Rosefield Solar DCO application

ROSEFIELD SOLAR FARM DCO APPLICATION EXAMINATION

WRITTEN REPRESENTATIONS

OF PRESTON FARMS LTD AND TCS BIOSCIENCES LTD

TITLE:
 FIGURE 3.9D
 INDICATIVE CONSTRUCTION AND OPERATIONAL
 ACCESS - PARCEL 3

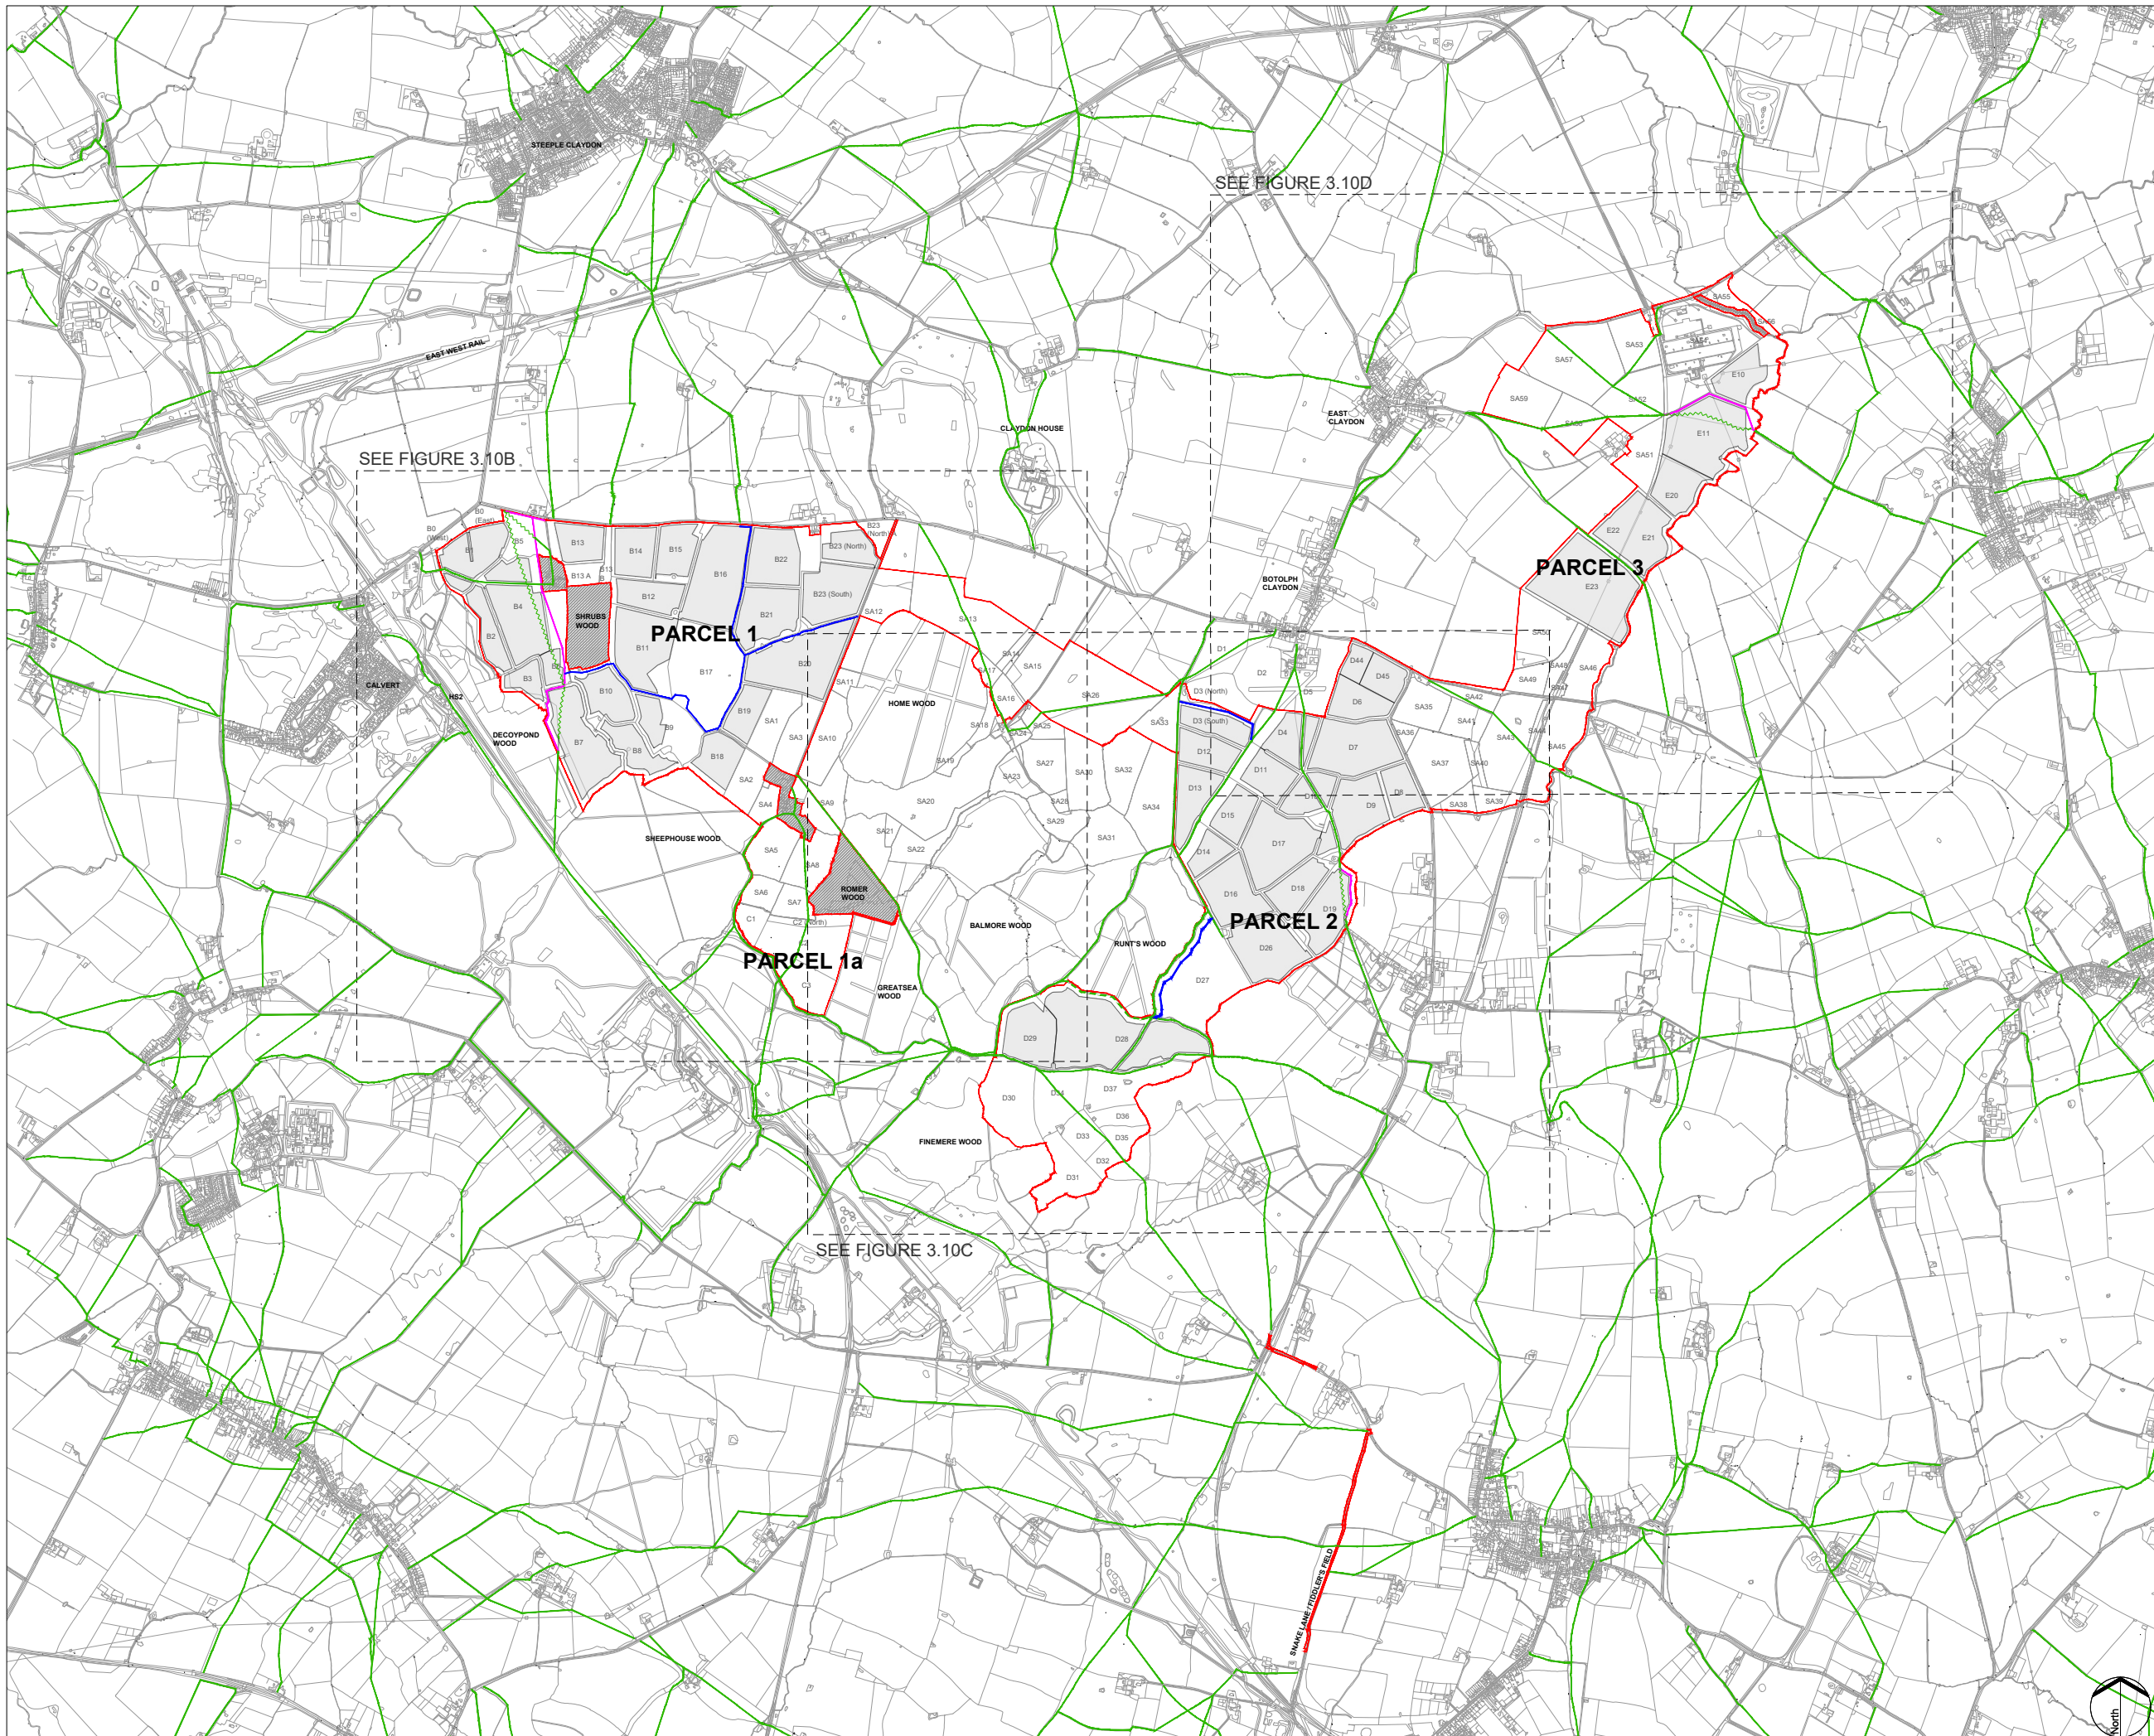
- (1) The DCO Proposals would bring extensive construction disruption to the Holding. In particular, access to Parcel 3 from Granborough Road (6/11 on the **[APP-008]** Land Plans) would come across a key part of the Holding and is not compatible with Preston Farms' operation.

- (3) The DCO Proposals position the solar farm substation in Parcel 3, adjacent to the Holding. So exposing livestock to disturbance from that direction (noise, some light and activity etc). No detail has been provided regarding necessary buffering and other measures to avoid disturbance of livestock.
